Following are comments on the Rammed Aggregate Pier (RAP) submittal for Seaside:

TITLE: AGGREGATE PIER PLAN
PROJECT: SEASIDE REHABILITATION
LOCATION: PORTLAND, ME
DATE: 12/7/2012
SCALE: AS NOTED

Drawing Name:
 Foundation Plan

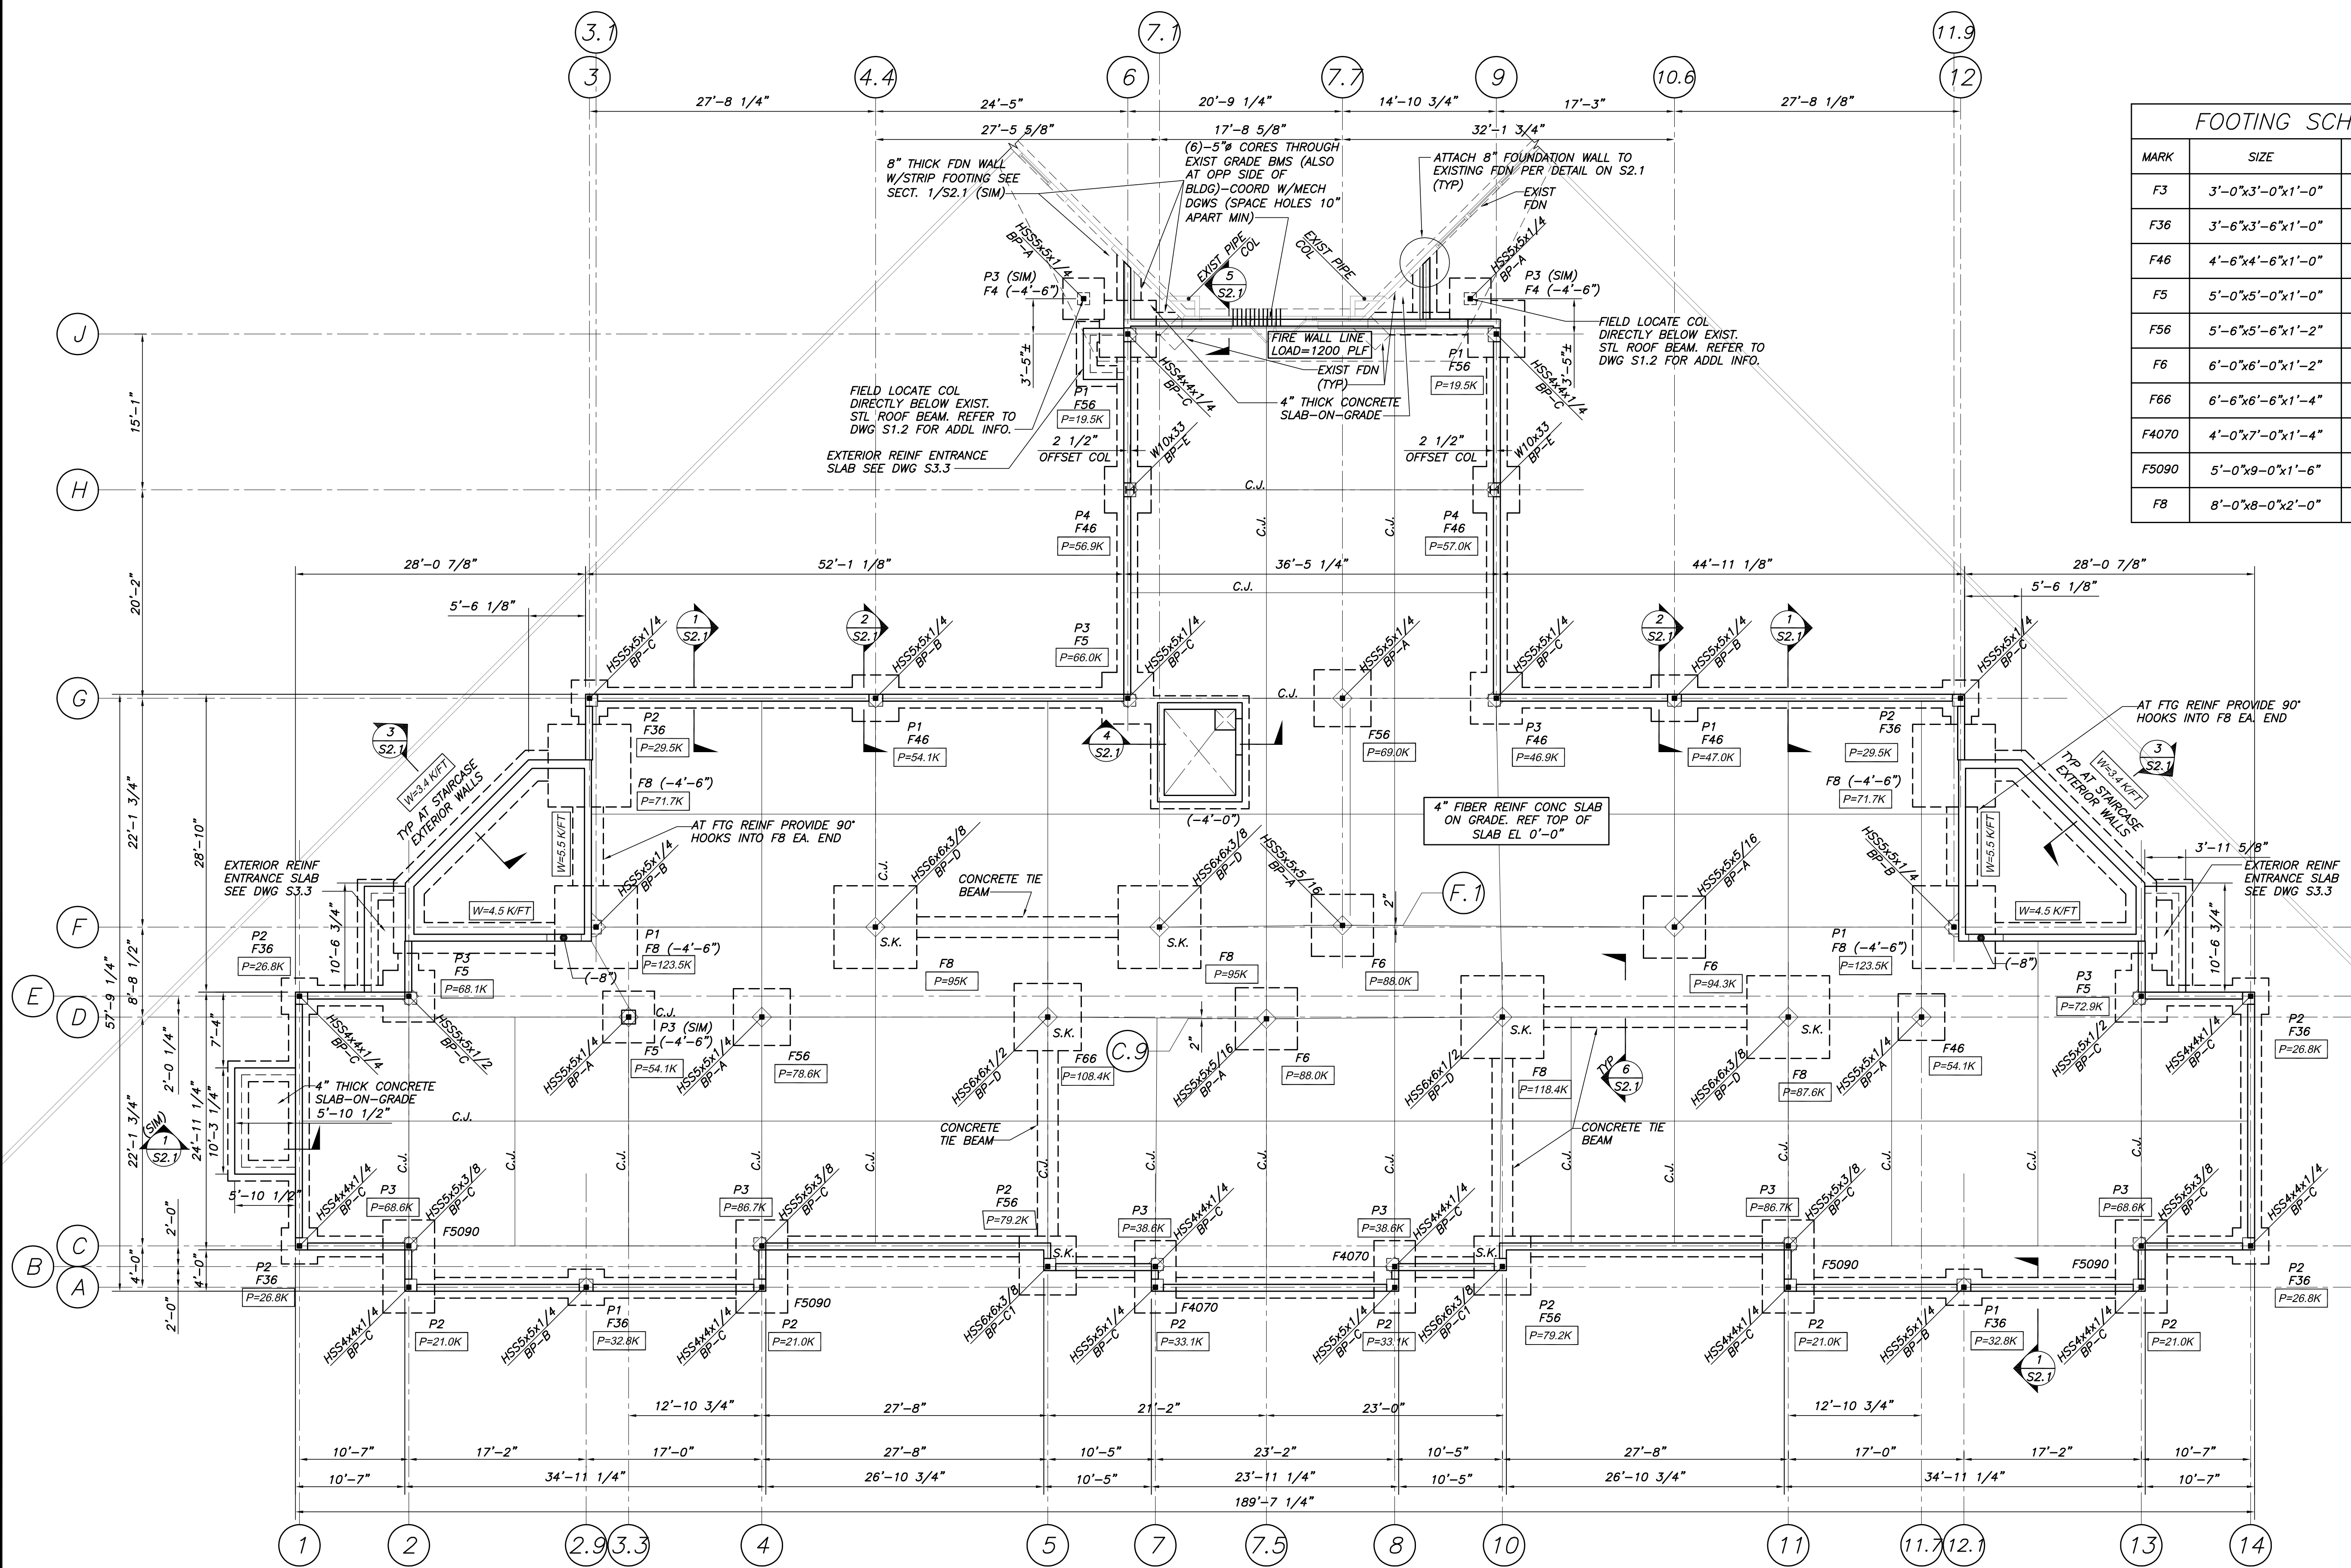
- 1) Add Grouted and Ungrouted RAPs at locations shown on attached plan
- 2) Add load tests at Grouted RAP 59 and Ungrouted RAP 203
- 3) Submit PL insurance certificate specific to the project
- 4) Submit lab test results for gradation and internal friction angle of aggregate for ungrouted RAPs
- 5) Submit mix design and batch method for grouted RAPs
